23 June 2008

MP07_0075 Major Project Application
Residential Subdivision - 45 Hearnese Lake Road, Woolgoolga
Response to Ecological Matters raised in the Department of Planning and
Department of Environment and Climate Change draft Adequacy Reviews

RESIDENTIAL SUBDIVISION  
LOT 21, DP714858 HEARNES LAKE ROAD, WOOLGOOLGA  
PLANNING NSW - CONSTRAINTS PLAN

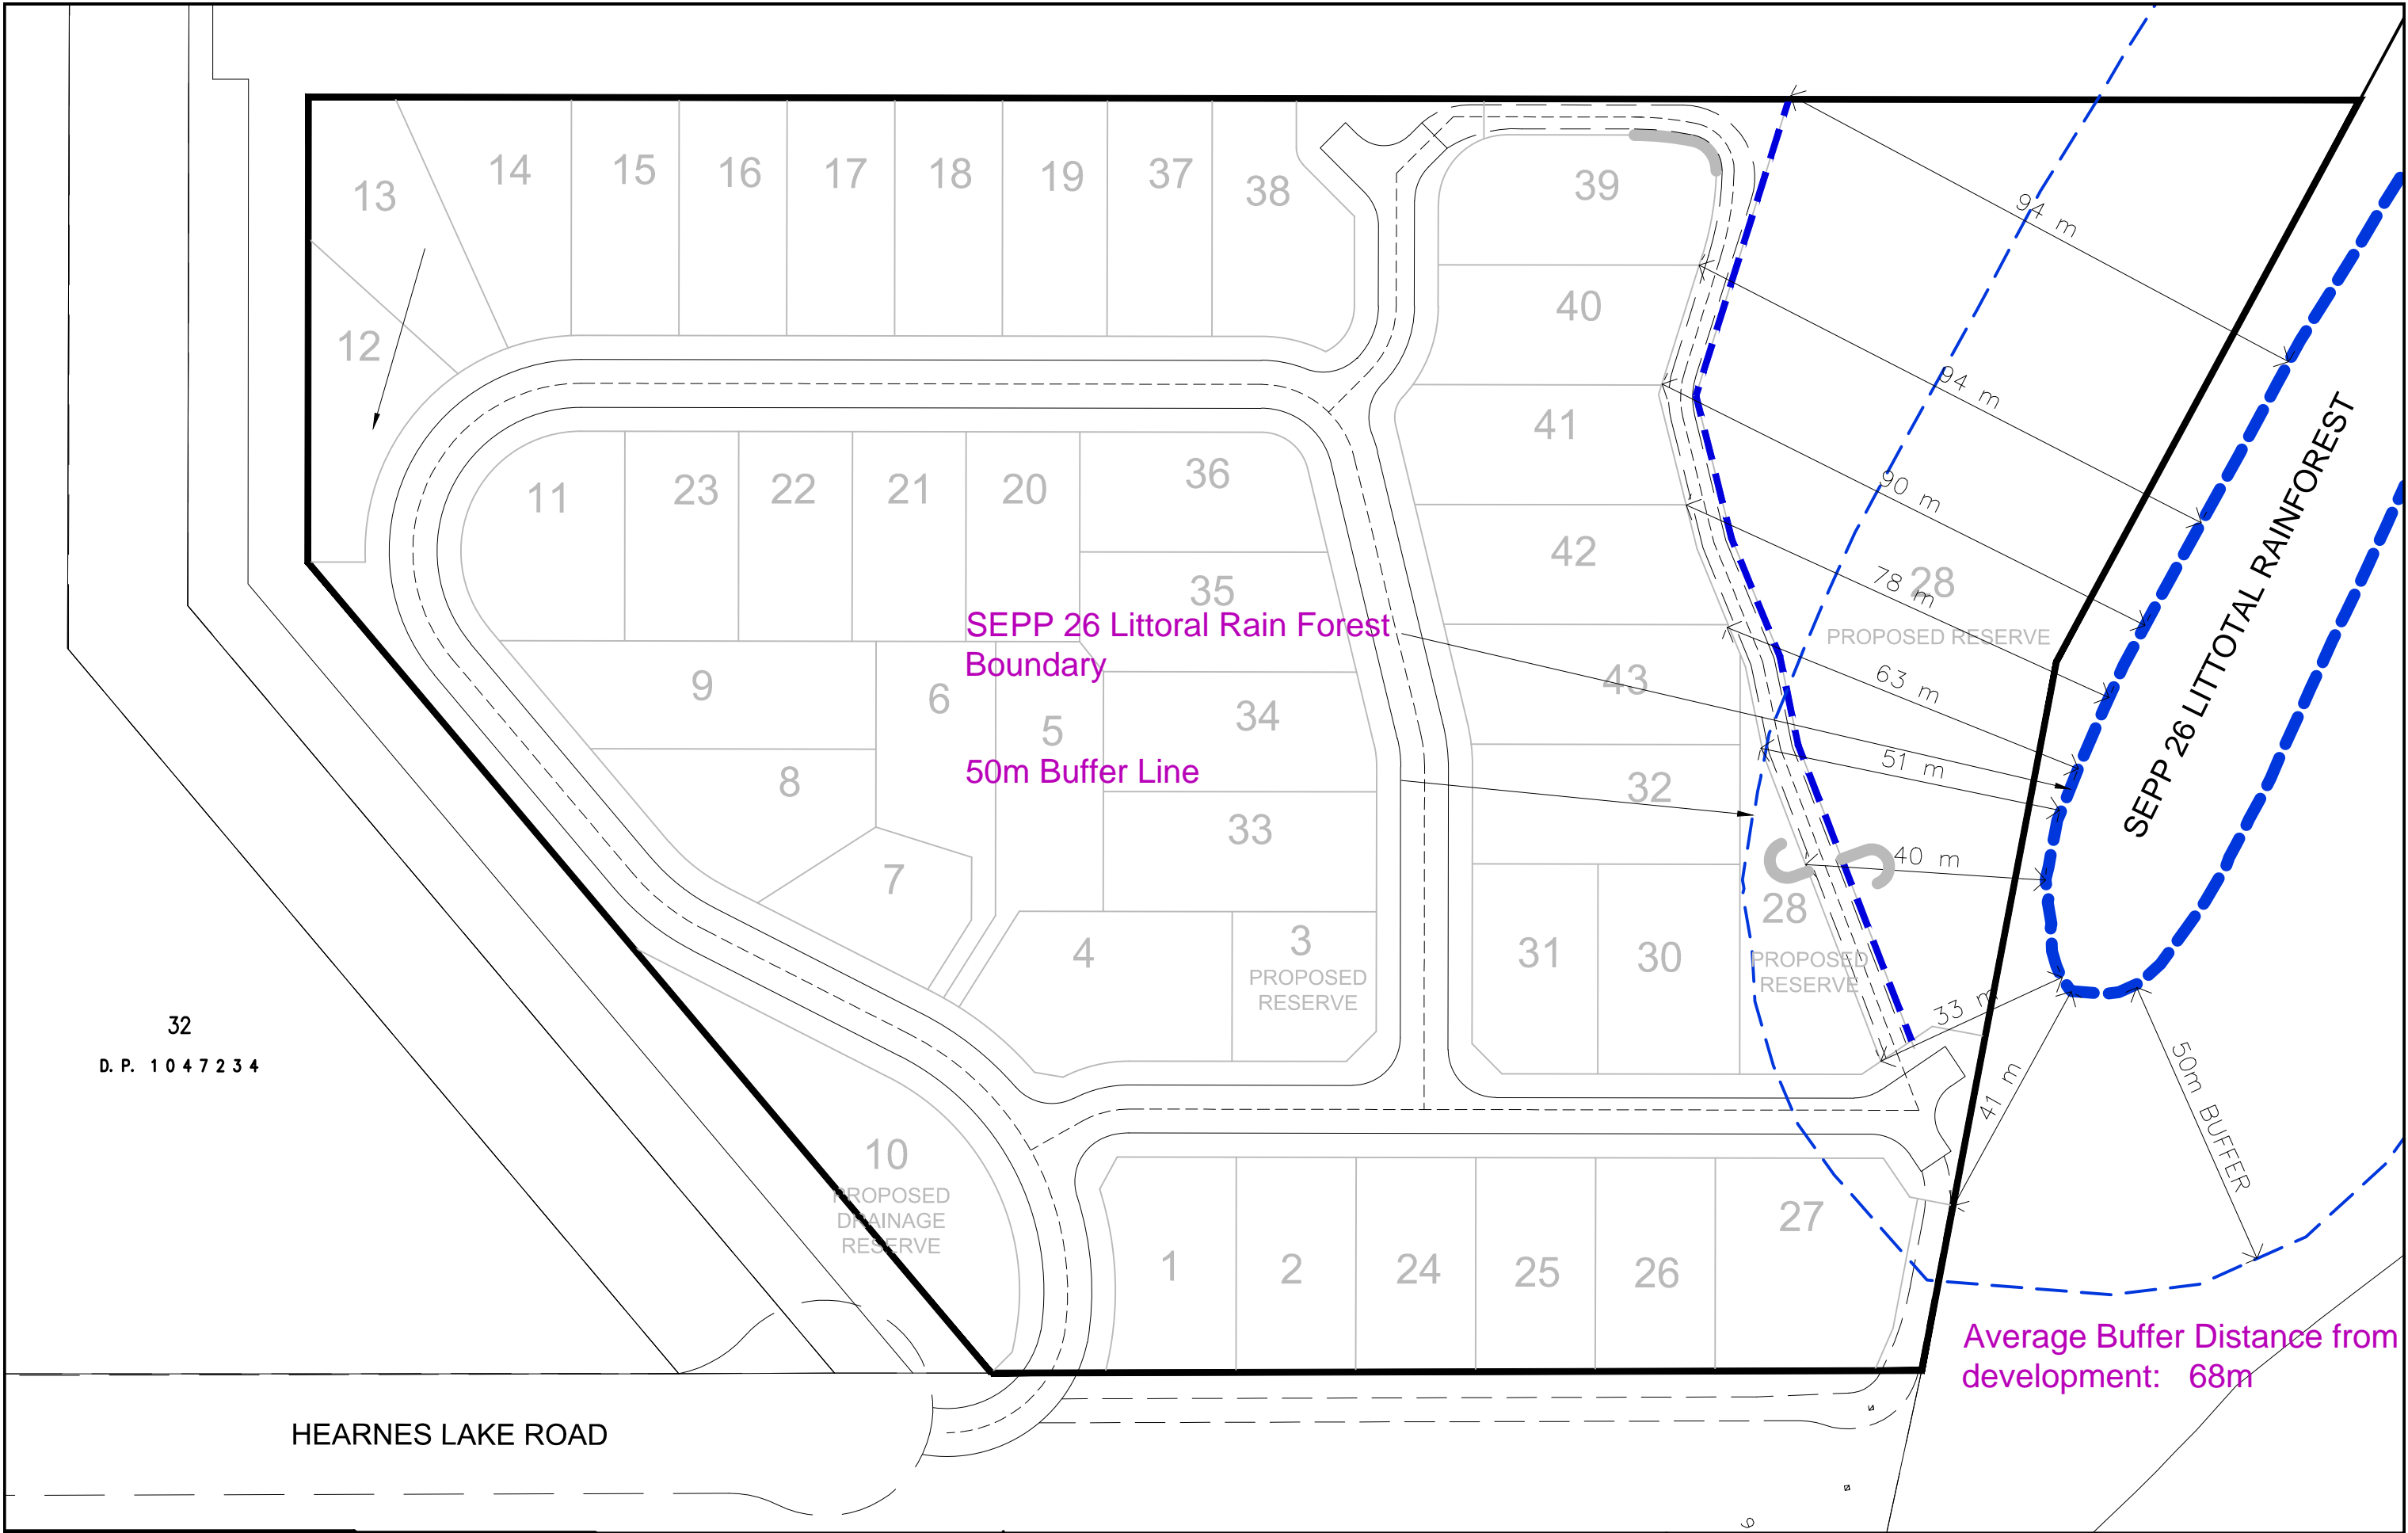
- *Buffers: Please overlay the Sainty map on the subdivision plan plus add 50m buffer lines from all EEC's, the wetland in the north-east corner and *Thesium australe*. Accurately map the wetland boundary using the wetland*

community criteria defined in Adam et al (1985) for mapping of SEPP 14 Coastal Wetlands. Please provide at an appropriate scale.

The proposal lies within the 'Sainty map' buffers, as required. This includes a buffer on the wetland in the northeast corner. Additional 50 metre buffers on all EECs and *Thesium australe* on the subject site would render almost the entire site constrained from development. It is considered that the mitigative measures proposed for remnant EEC and *Thesium australe* on the subject site are sufficient to offset any potential impacts on them.

Adam et al.(1985) criteria mapped SEPP 14 Coastal Wetlands rapidly and coarsely, to the extent that this particular wetland on the subject site was omitted or overlooked from the original SEPP 14 mapping undertaken by Adam et al. The ELA 2007 report notes that this wetland qualifies as SEPP 14 Coastal Wetland, although it is not officially mapped as SEPP 14 wetland. The map provided in the ELA (2007) report is a reasonably accurate representation of the extent of the wetland at the time site surveys were undertaken.
